FW: Planning Applications 2025/44/92737E and 2025/61/92713 - Flood Exceedance Plan

**Subject:** Planning Applications 2025/44/92737E - Flood Exceedance Plan

Re: Drainage Plan [id1113906] 13/11/2025-PV2511-APP-92-XX-DR-C-2501-P02  
Flood Exceedance Plan.

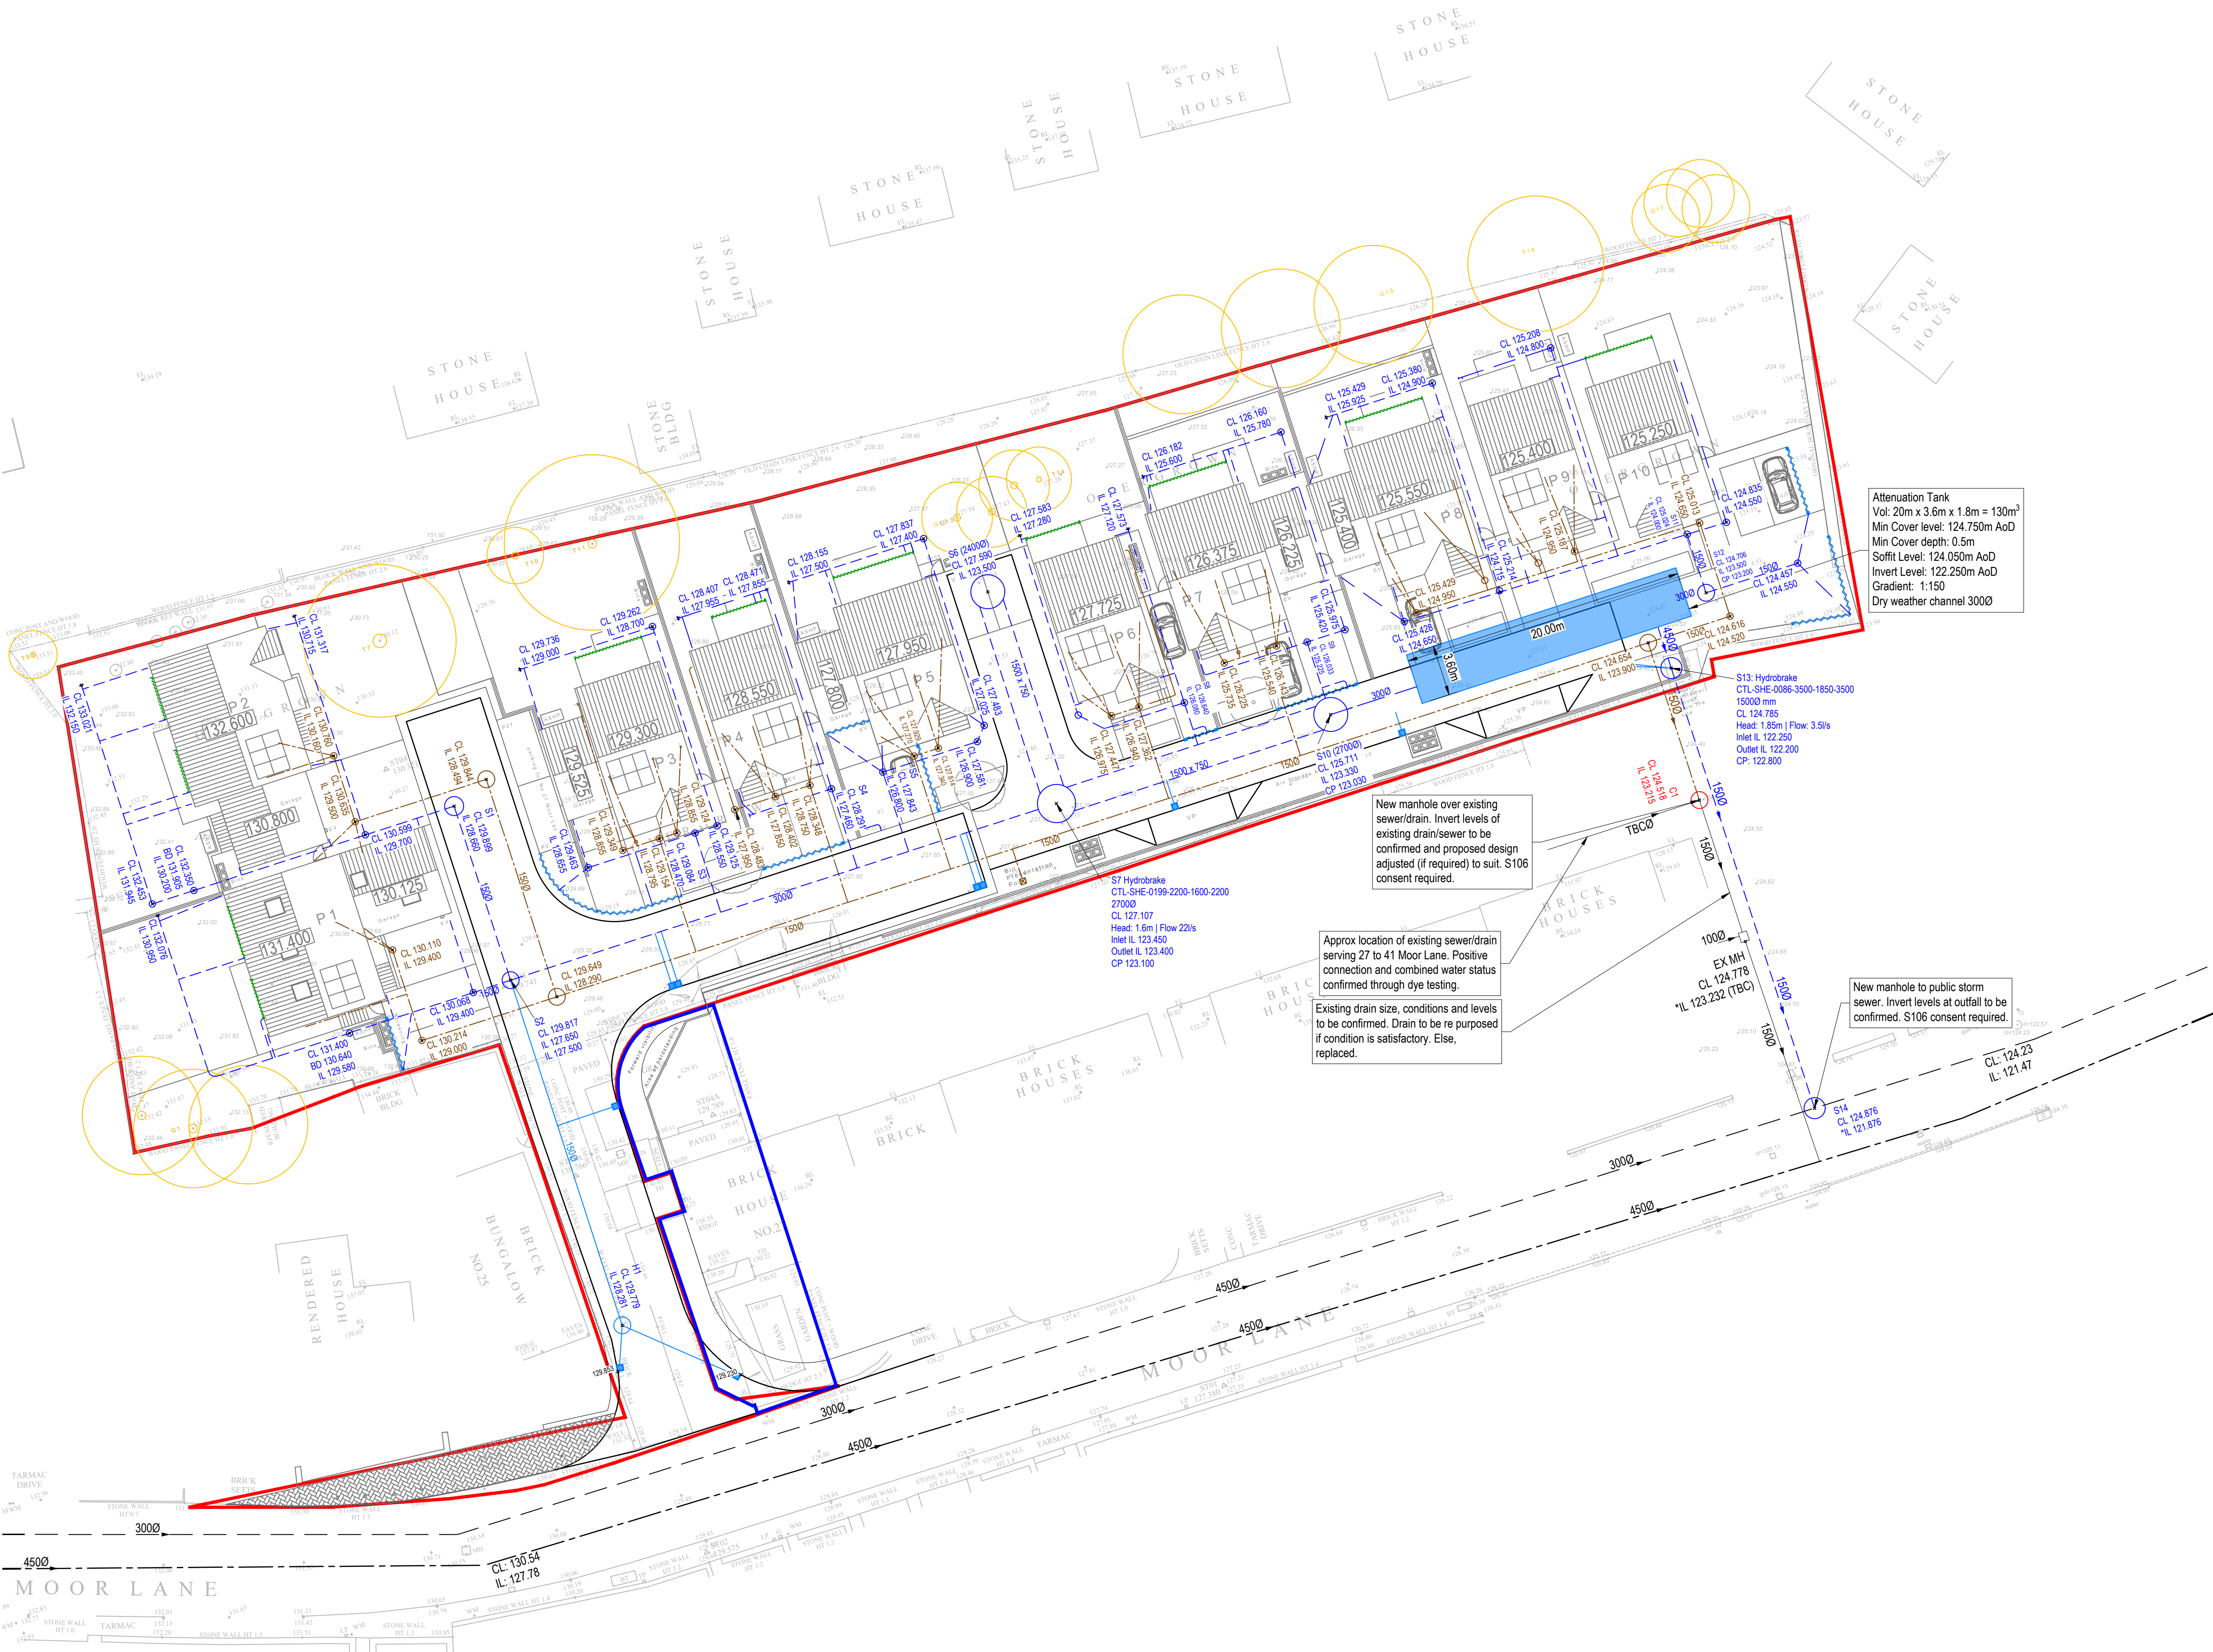
The above exceedance plan is actually showing and stating that the flood exceedance route is being directed to 21 Summerdale's private garden. On the above plan there is a red arrow indicating the direction of the flood exceedance flow and also states "Flood exceedance route heading towards soft landscaping at rear garden of 21 Summerdale".

This developer's flood exceedance plan is clearly increasing the risk of flood to my property and is therefore not complying with the requirements of the National Planning Policy Framework.

A developer cannot unilaterally state that a flood exceedance route will be directed into a private garden without appropriate legal rights and permissions.

My husband and I have **NOT** been approached for permission to use our garden for this flood exceedance route and I am formally informing you, Kirklees Council, that we do **NOT** give permission for this flood exceedance to be directed towards or be allowed to access our property.

As the other drainage pipework from this development is being directed through 41 Moor Lane's garden to Moor Lane and as of 28th November 2025 this is a **vacant council owned property** which is being refurbished having new fencing, gates and gardening. Why haven't Kirklees Council used this garden for the flood exceedance route?

This developer is clearly increasing the flood risk on third party properties and designing a flood exceedance route to flow into neighbouring property.

How can a plan, that is supposed to be there in perpetuity, be based on something that is outside the developers control and based on something which could be changed by the current or future owners of this property, i.e. soft landscaping removed (flagging etc.)?

I am therefore writing to you directly to request that these factors are taken into account when you are considering discharging Condition 17, The Flood Exceedance Route, on this current exceedance plan for this planning application.
